MEMORANDUM

TO: Jean Fraser, Planner
FROM: David Senus, P.E. & Ashley Auger, E.I.T.
DATE: March 3, 2014
RE: 421 Warren Avenue, Preliminary Level III Site Plan Application

- Preliminary Level III Site Plan Application and attachments dated February 12, 2014, prepared by FST Engineers on behalf of PH Warren Avenue, LLC.
- Engineering Plans, Sheets C-1.0, C-1.1, C-2.0, C-2.1, C-3.0, C-3.1, C-4.0, C-4.1, C-4.2, C-4.3, C-5.0, C-6.0, C-6.1, C-6.2, C-7.0, and C-7.1, dated February 10, 2014, prepared by FST Engineers on behalf of PH Warren Avenue, LLC.

SHEET TITLE **GRAVEL WETLAND DETAILS**

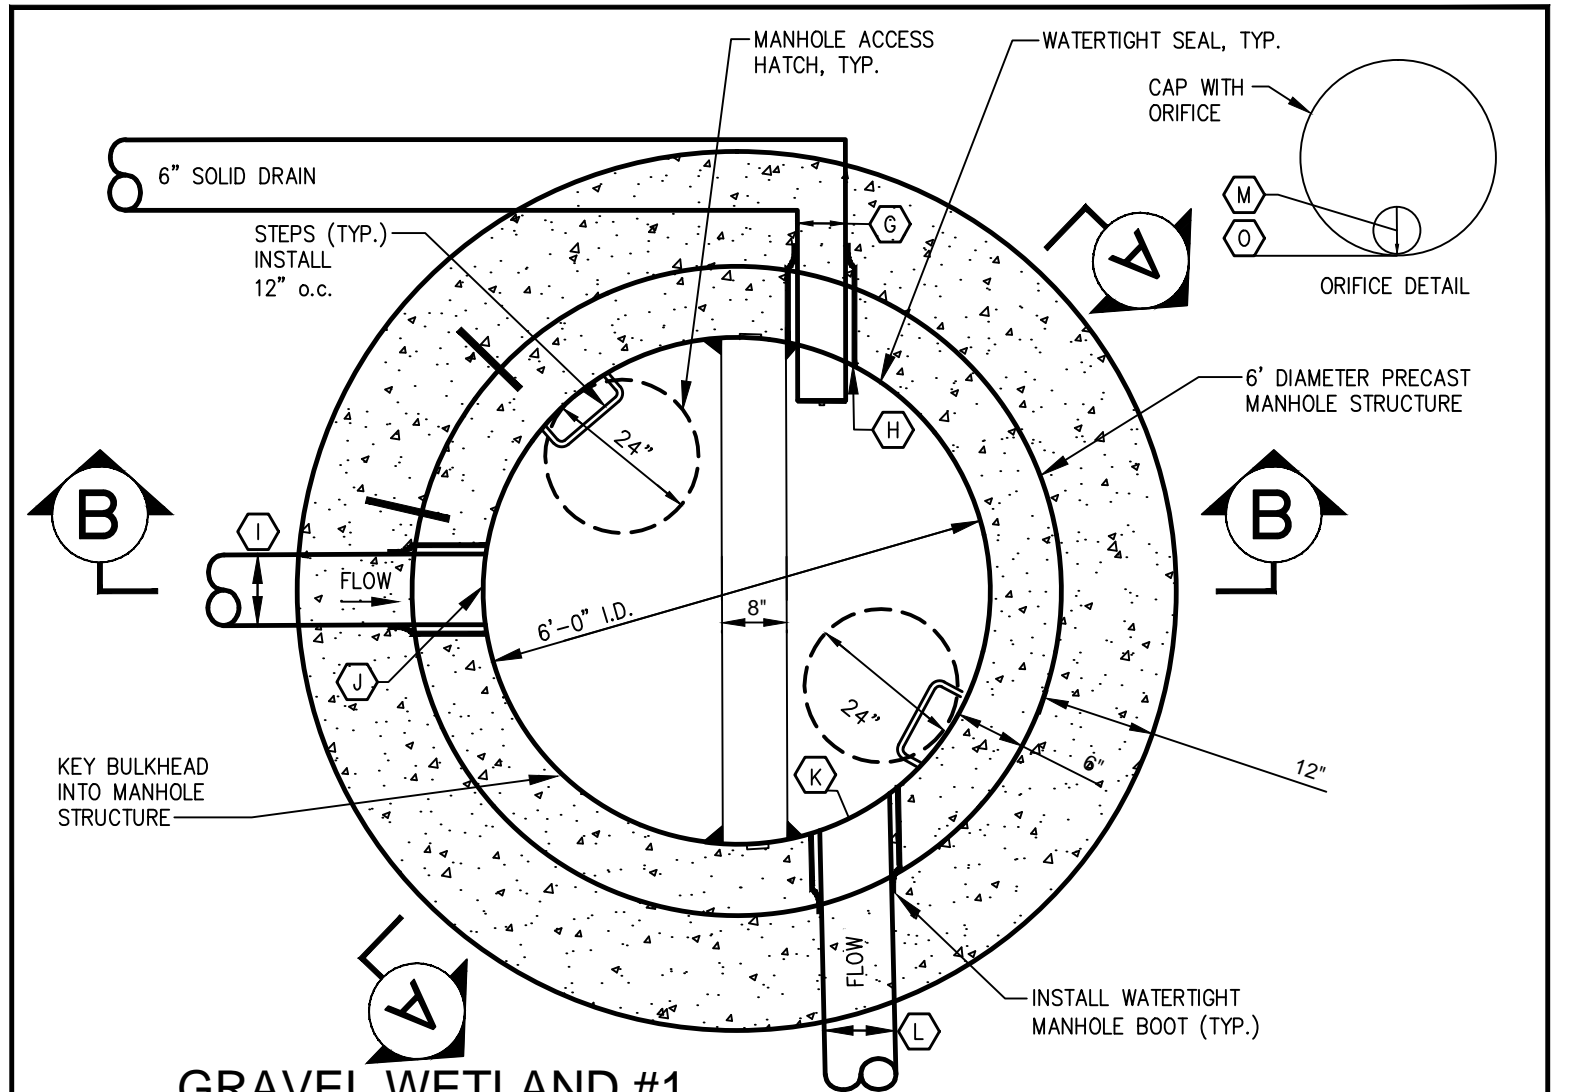
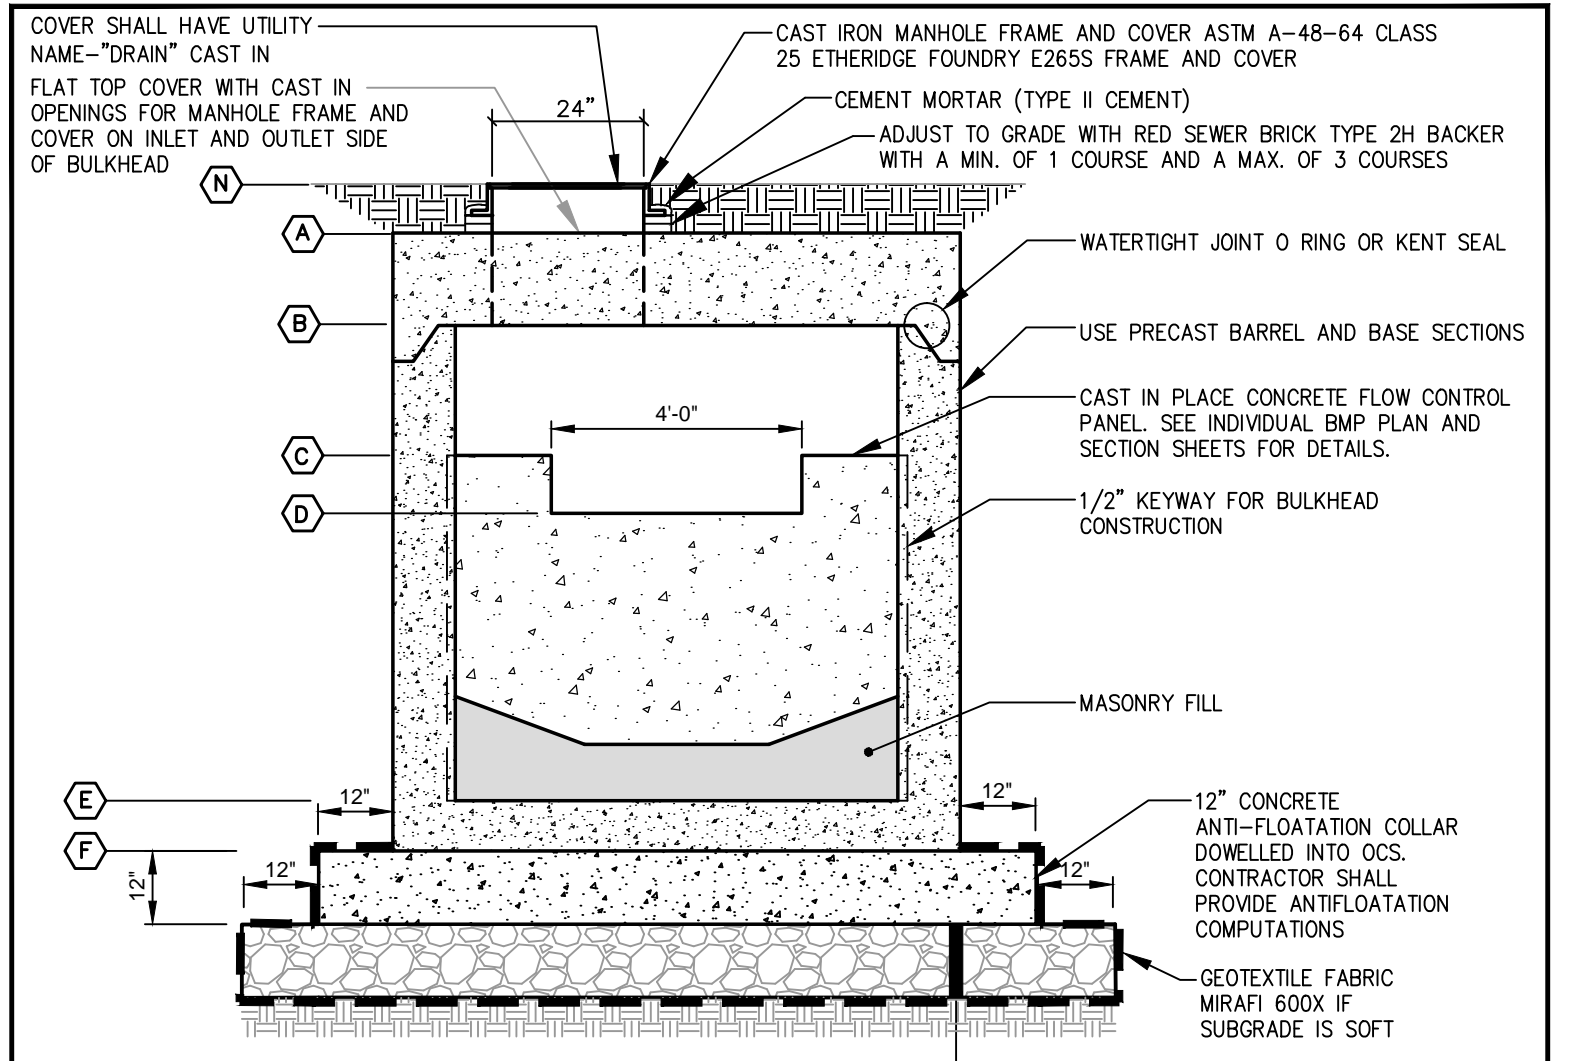
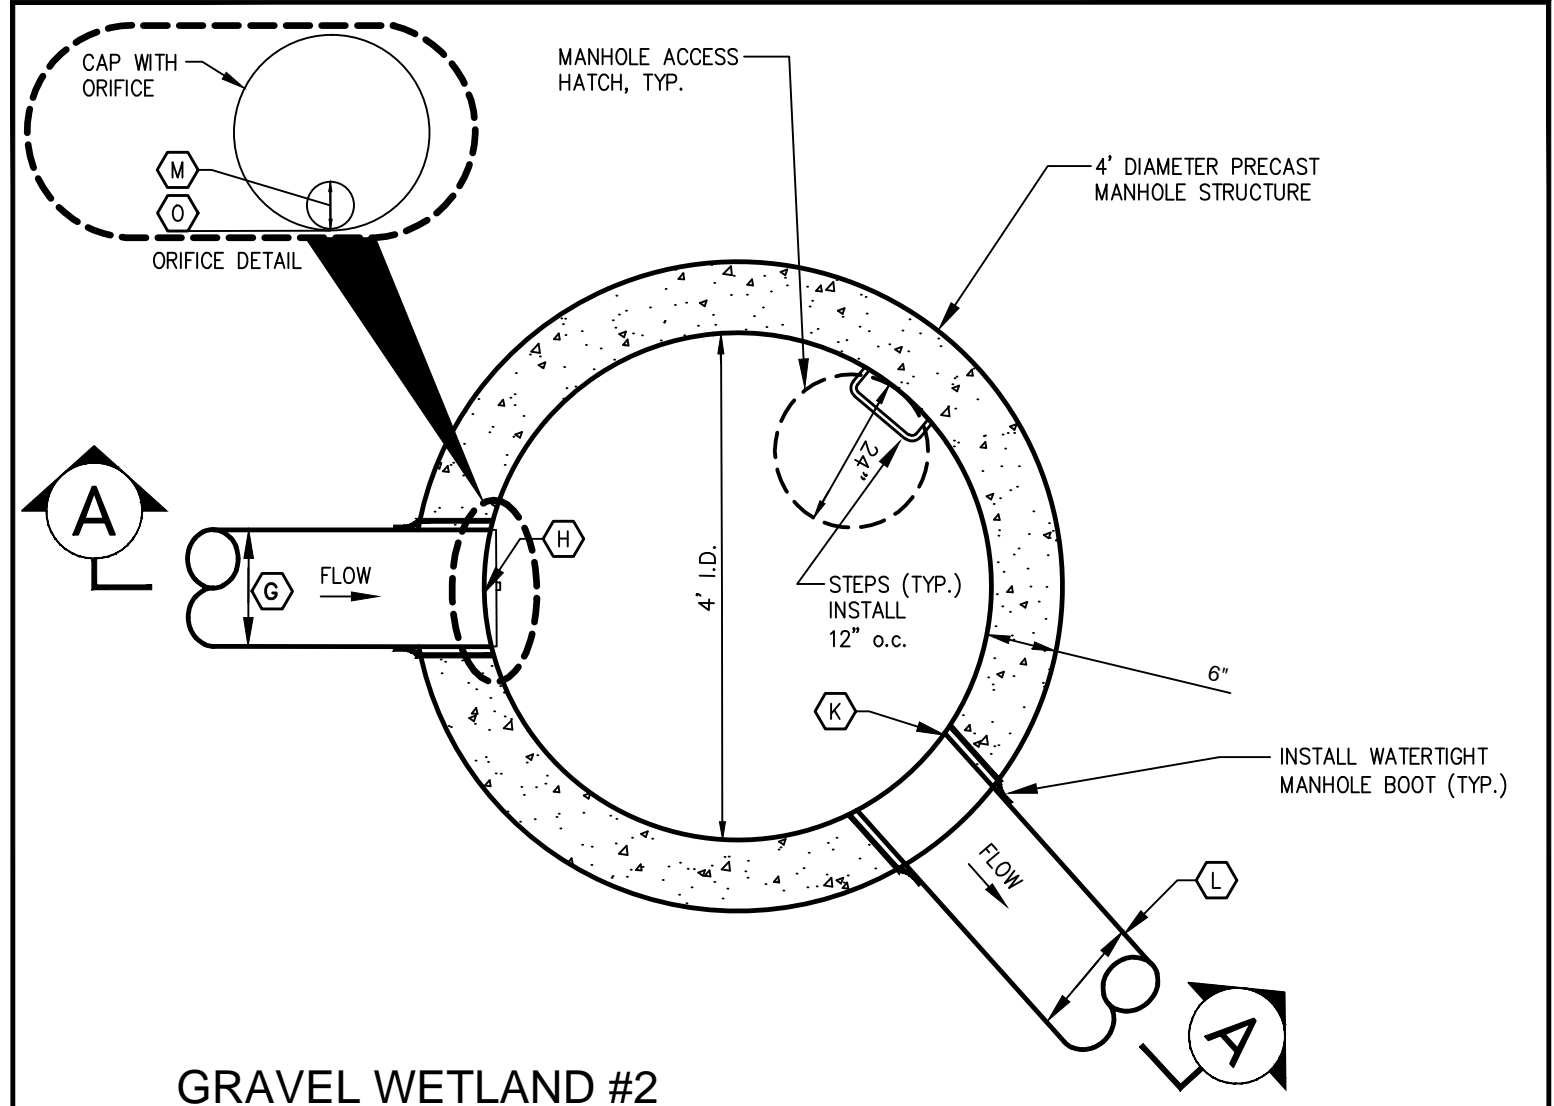
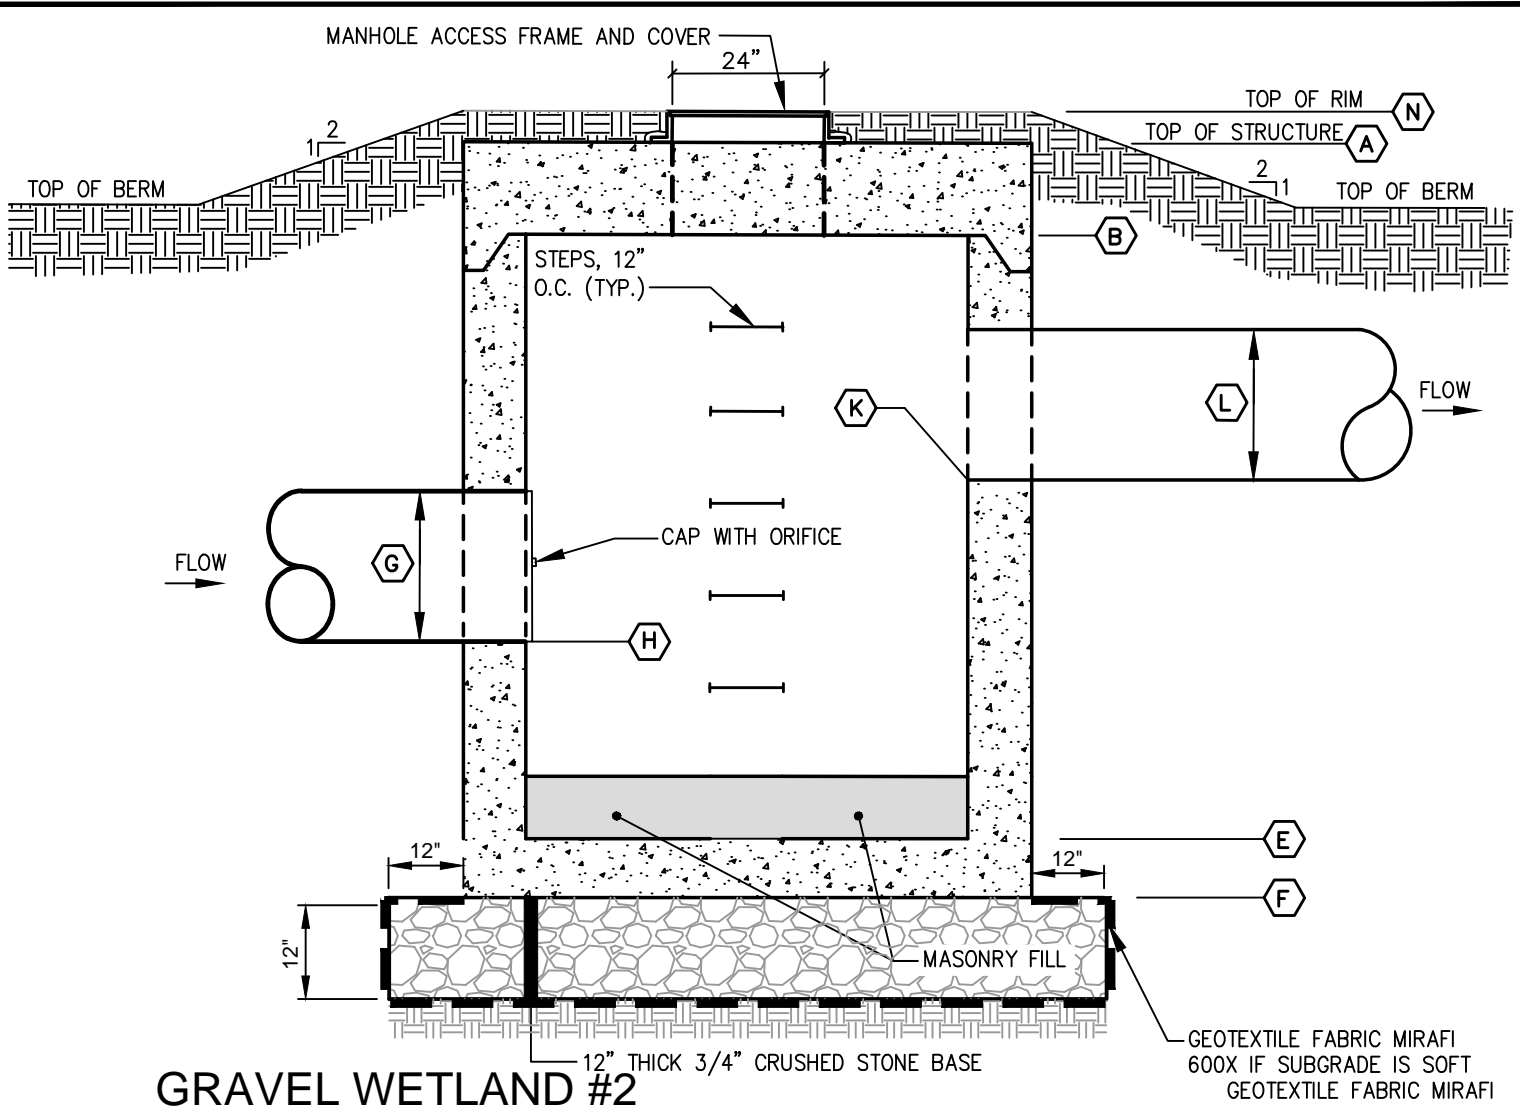
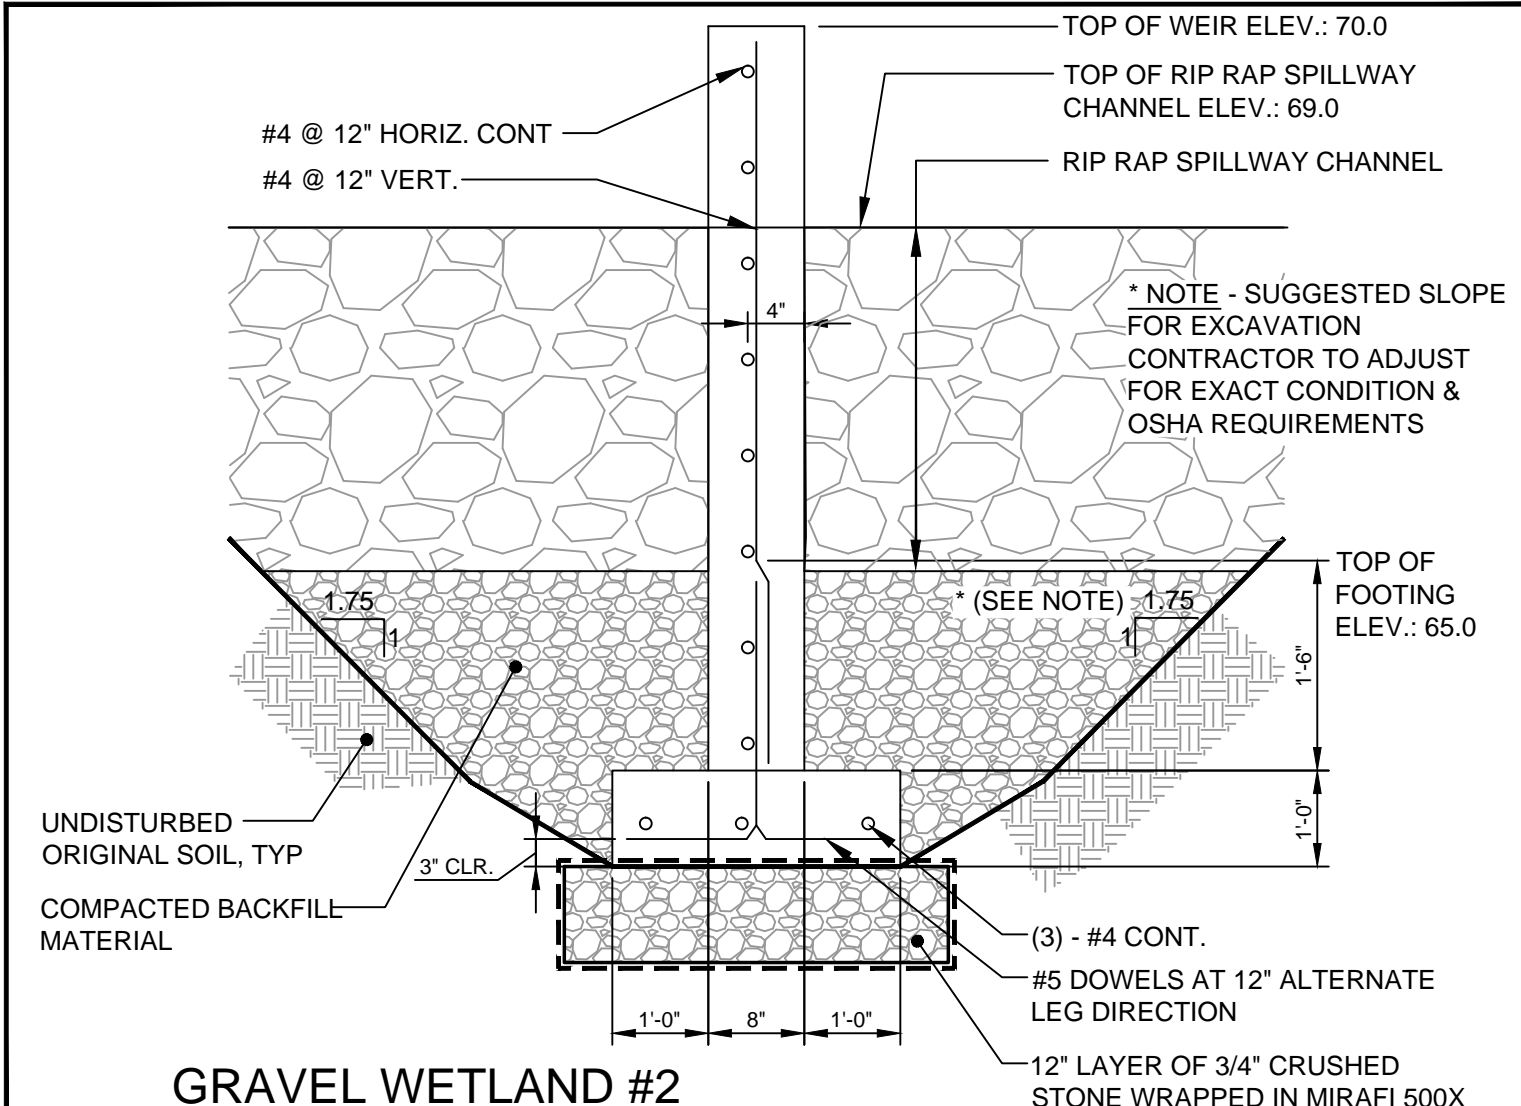
- e) As noted on the plans, the Applicant intends to add outlet elevation information to the outlet control structure details for both gravel wetlands as part of the final submittal. Without this information we cannot verify the routing or model inputs for Pond 4P (GW2) or Pond 5P (GW1). When the outlet control structure elevations are incorporated into the final submittal, please revisit or provide explanation on the routing methodology for GW1 & GW2 in the HydroCAD model; we are unable to follow the routing as currently presented.

- b) The Applicant has submitted drawdown calculations for sizing the gravel wetlands' outlet control structure orifice control devices; however, the orifices do not appear to be specified on the design plans/details. The Applicant should clarify with the final design package.
